Application for Planning Permission

Development: Conversion of existing single residential unit with associated commercial space to form 3 No residential units together with associated works. This application affects the setting of listed building, affects the character and appearance of the Arundel Conservation Area, is in CIL Zone 2 and is CIL Liable as new flats.

Location: Sparks Yard 18 Tarrant Street Arundel BN18 9DJ

## **PARTLY IMPLEMENTED AND PROPOSED EAST AND WEST ELEVATIONS**

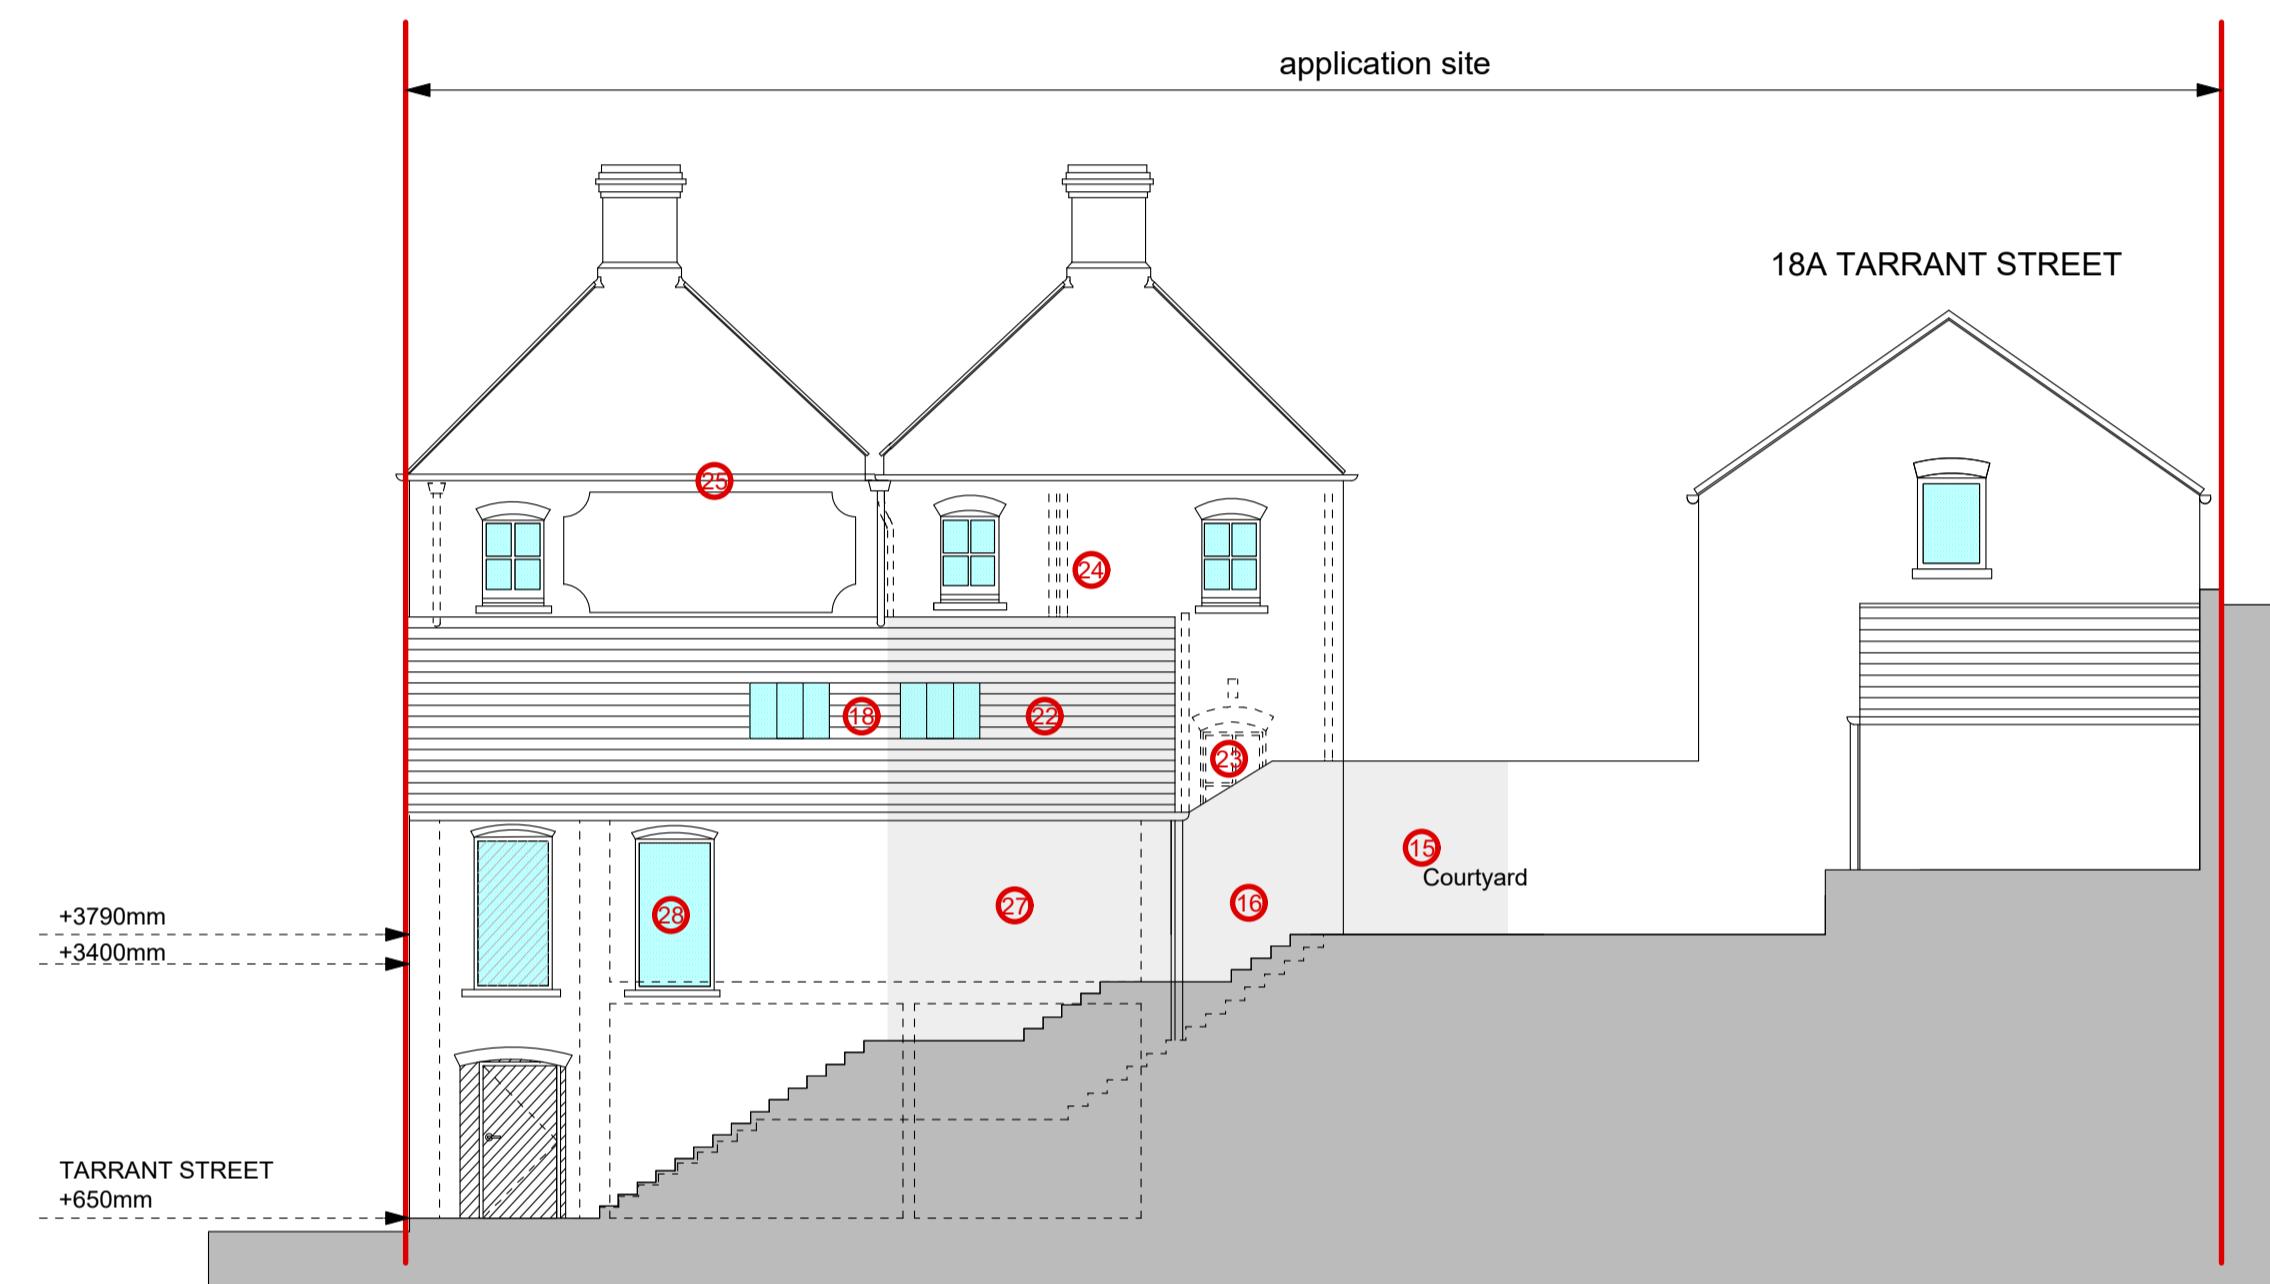
The proposed second floor plan and east elevation do not accord. Please amend accordingly.
